CELBRIDGE HAZELHATCH MOBILITY CORRIDOR

Responses to Submissions on Section 177AE Consent Application

MDT0902-RPS-00-XX-SH-Z-1001

11th February 2026

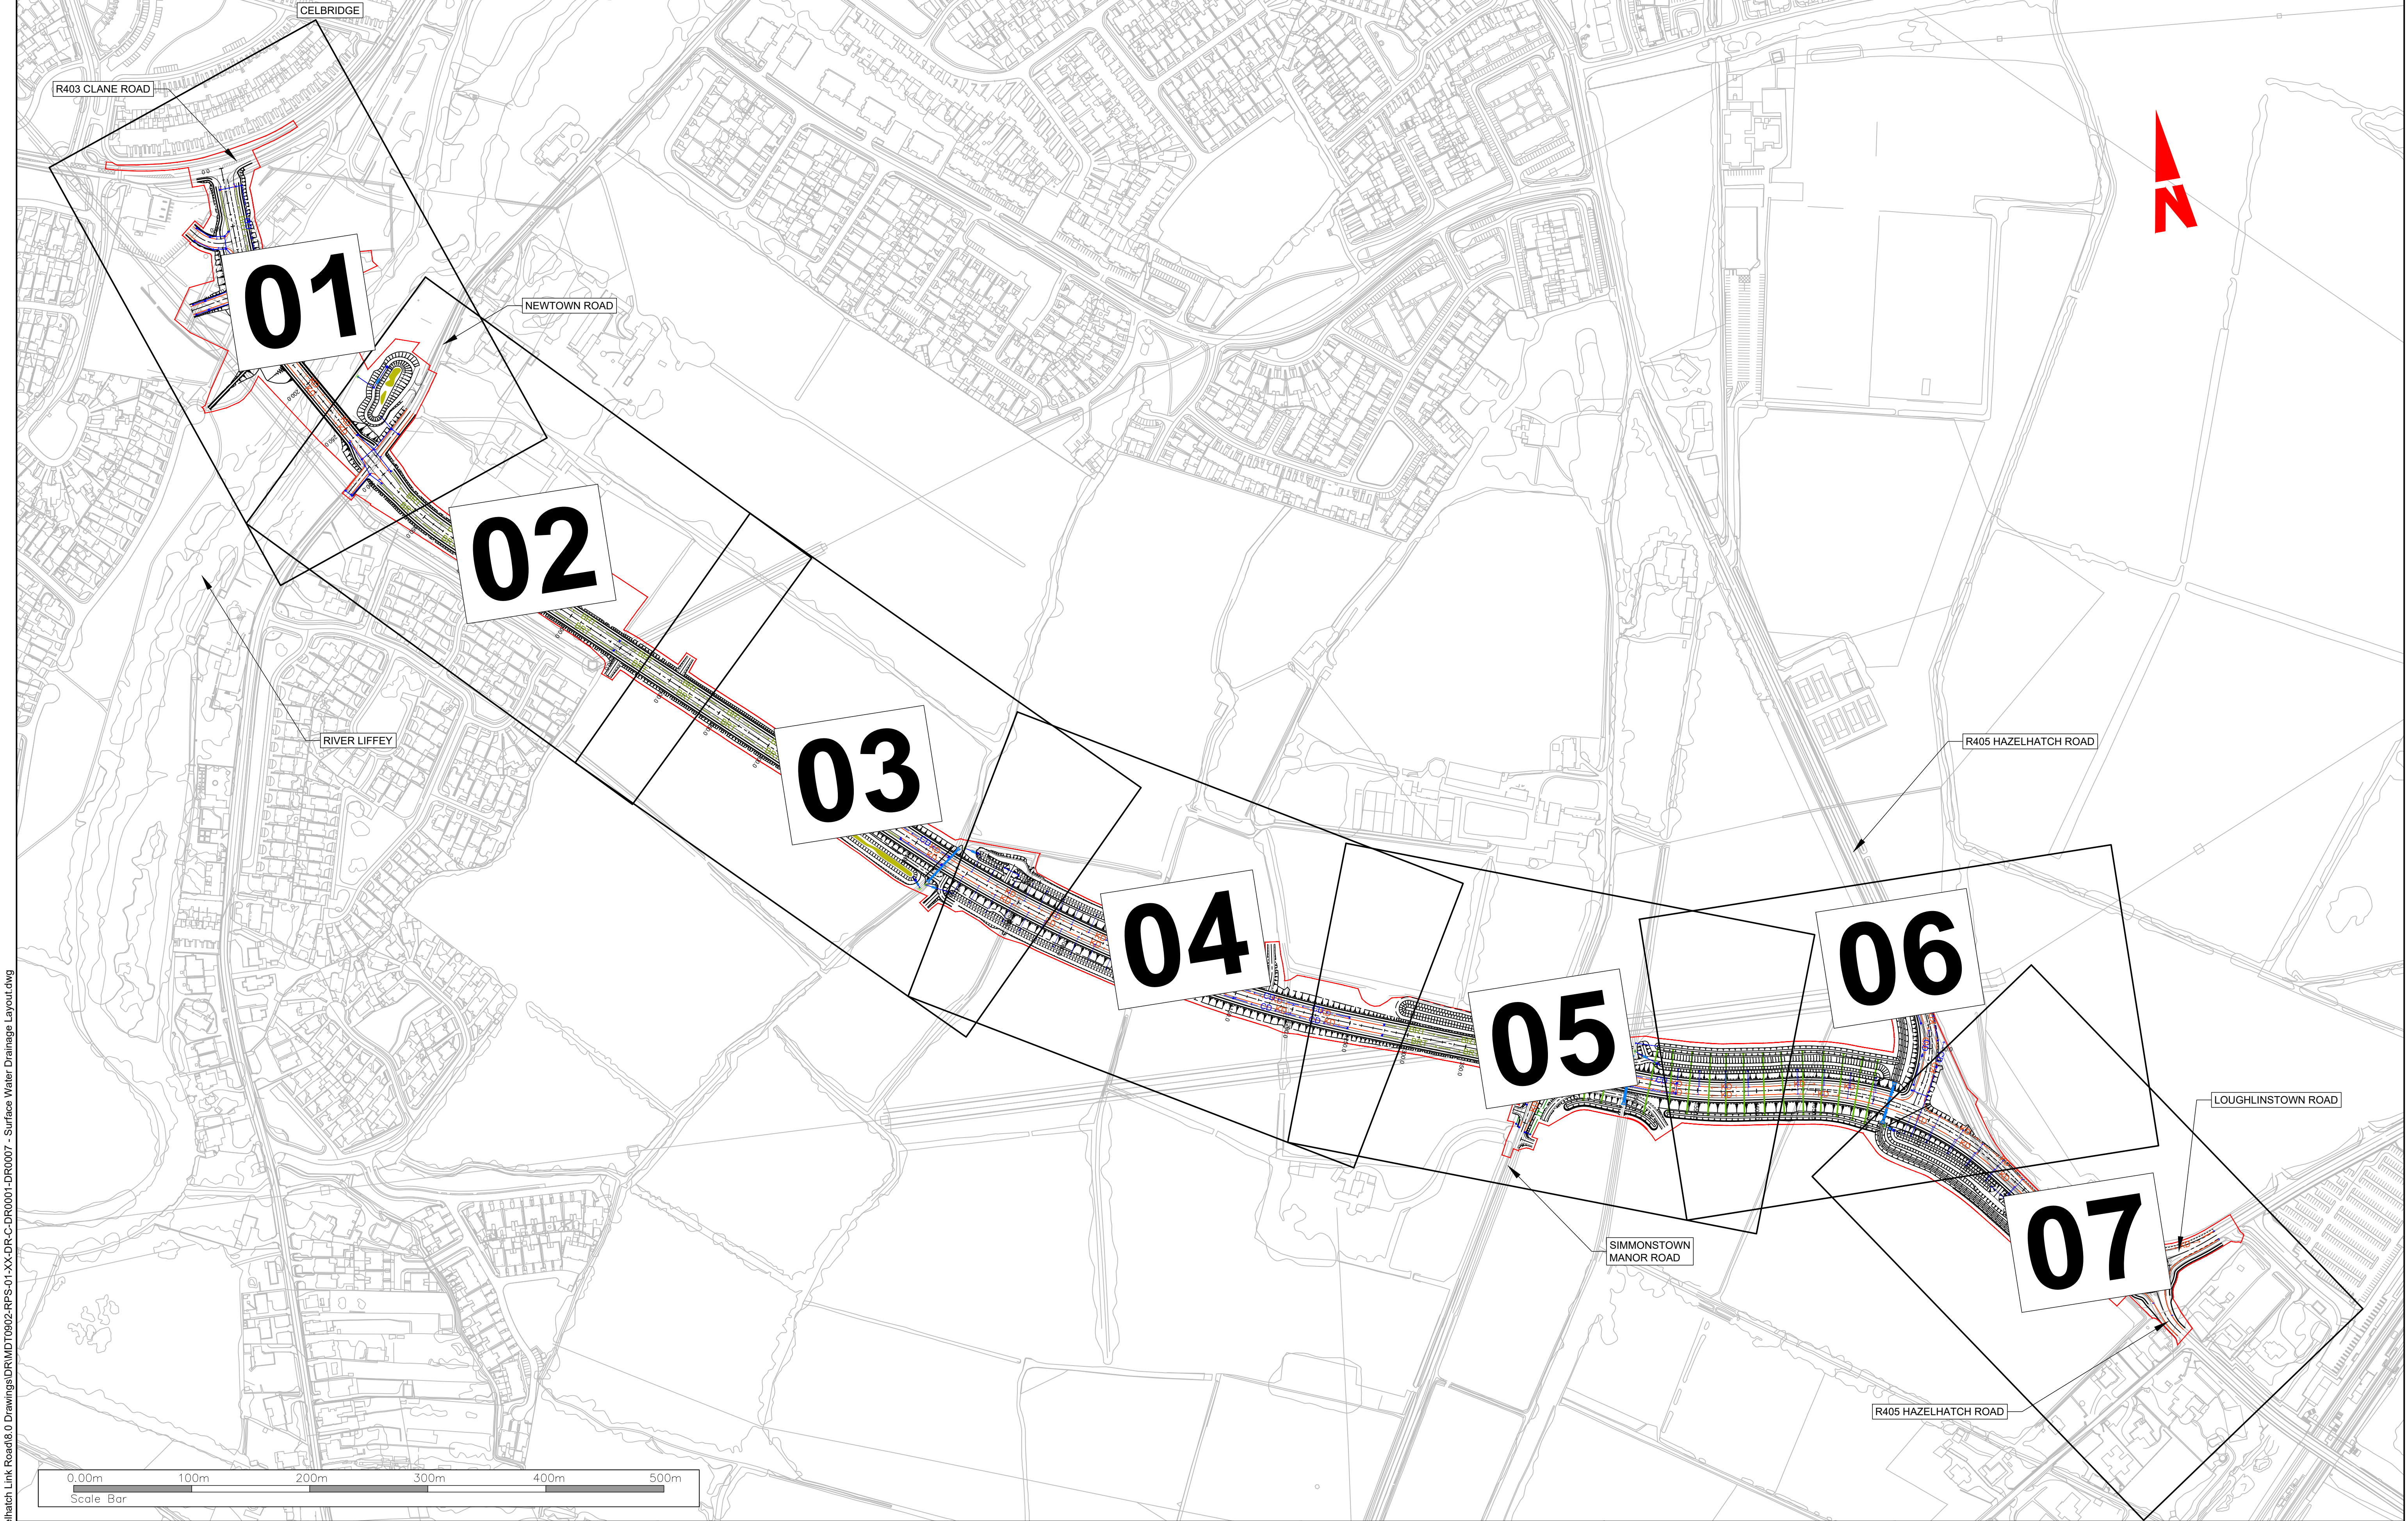
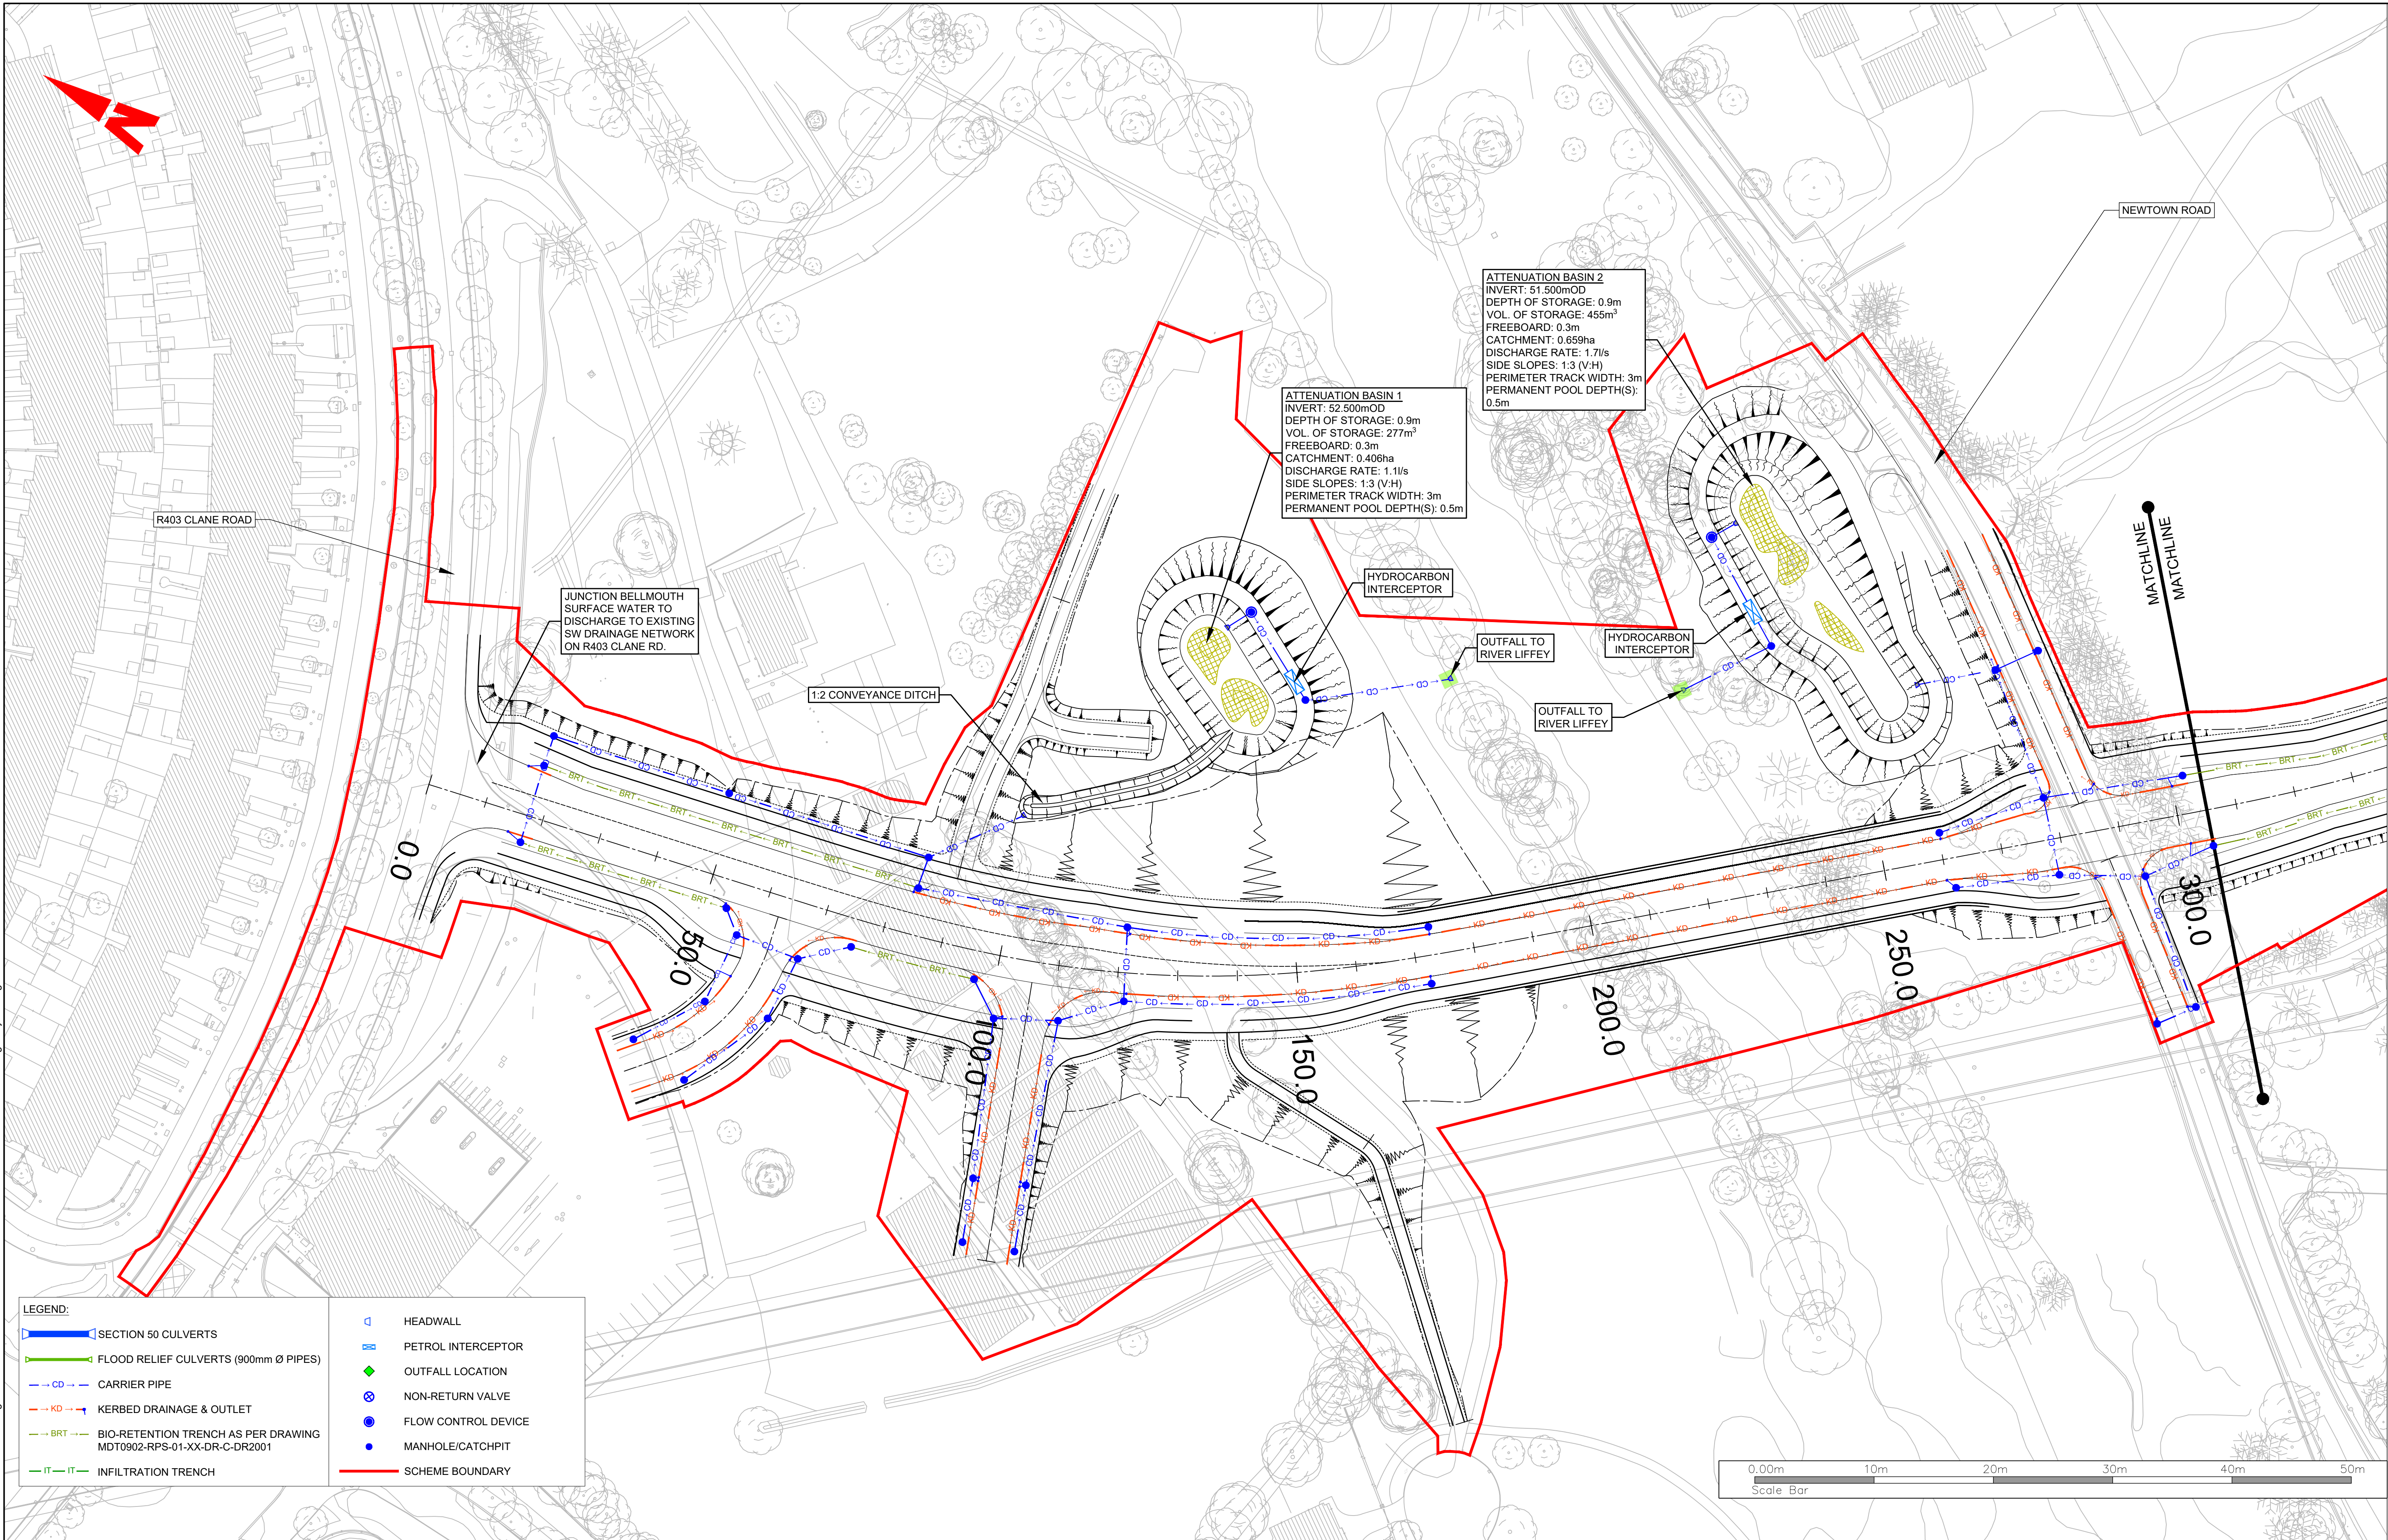
12.	All discharges must follow the European Communities (Surface Water) Regulations 2009 and the European Communities (Groundwater) Regulations 2010.	The proposed surface water drainage layout for the proposed development is illustrated on drawings MDT0902-RPS-01-XX-DR-C-DR0000-DR0007. Various SuDS features are incorporated into the design of the proposed development to reduce operational phase pollutant run-off into watercourses and pollutant infiltration into groundwater in accordance with the European Communities (Surface Water) Regulations 2009 and the European Communities (Groundwater) Regulations 2010 and approval is sought on this basis and subject to such further Conditions as may be imposed by the Competent Authority.
